I am writing regarding a householder planning application reference: 2024/62/93588/W
Erection of two storey and single storey rear extension at 114 Slaithwaite Road,
Meltham, Holmfirth, HD9 5PW.

Proposed ground floor layout (1:50)

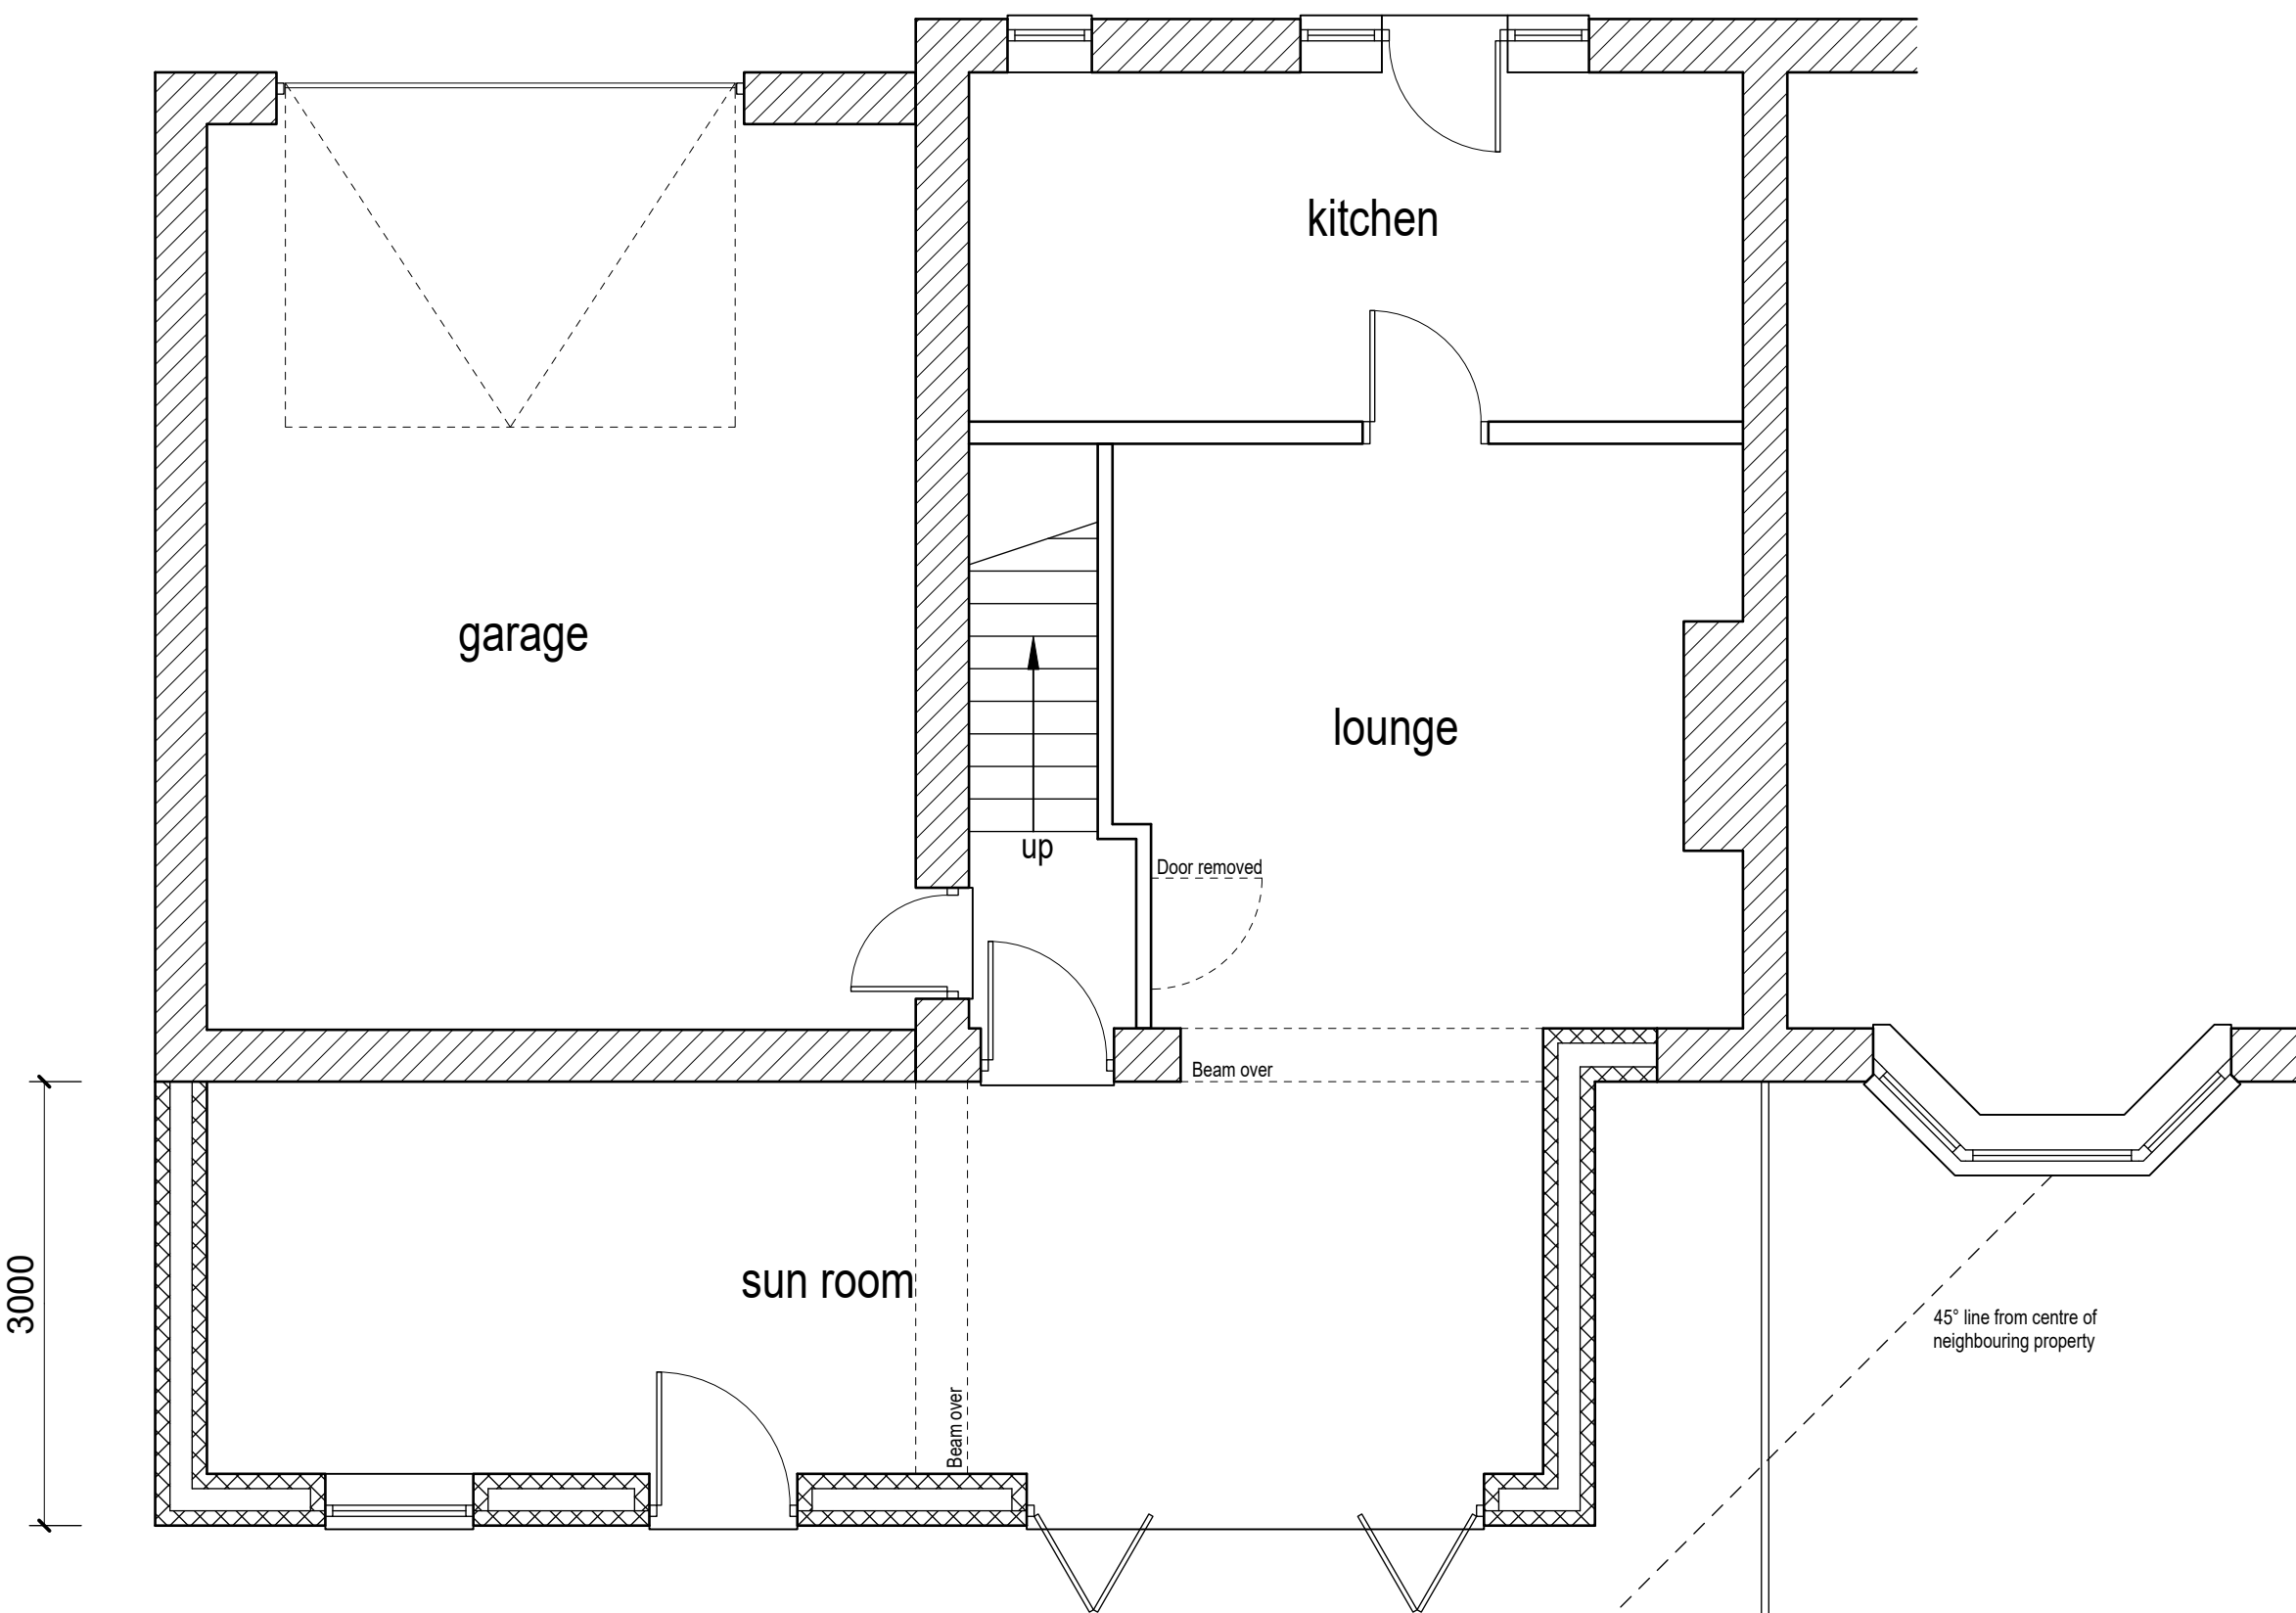
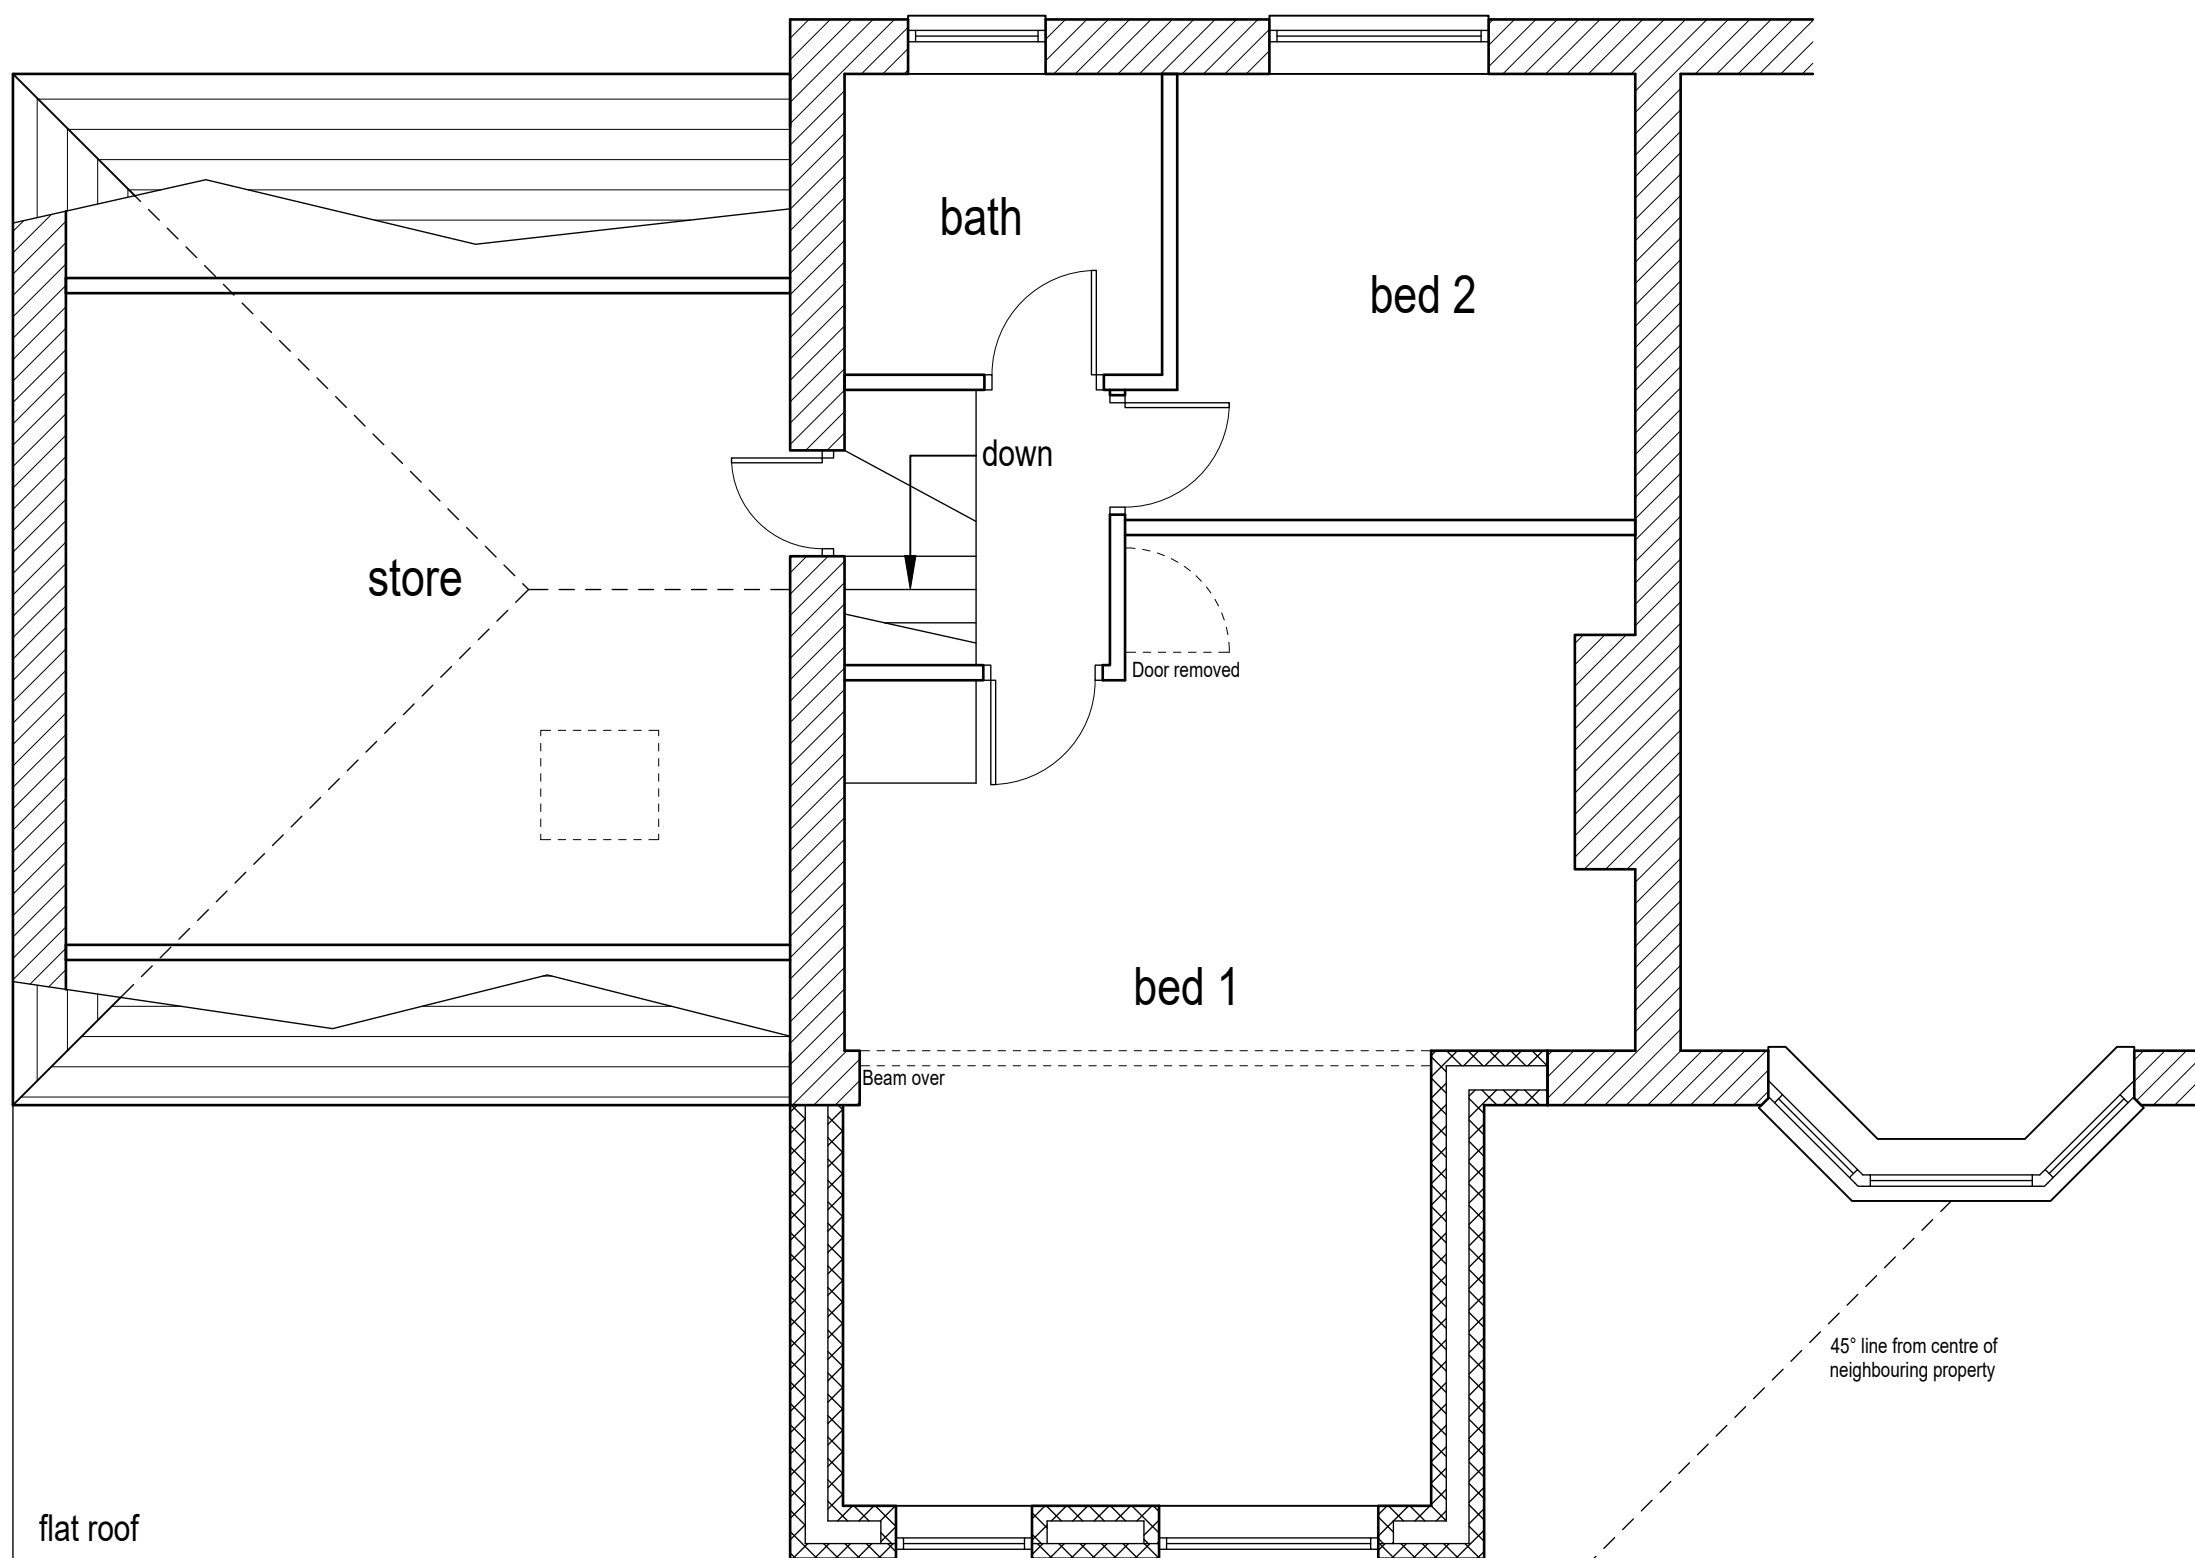
- Recently updated plans submitted show the 45 degree projection line to the centre of the bay window rather than the edge which again impacts on the natural light of my property.
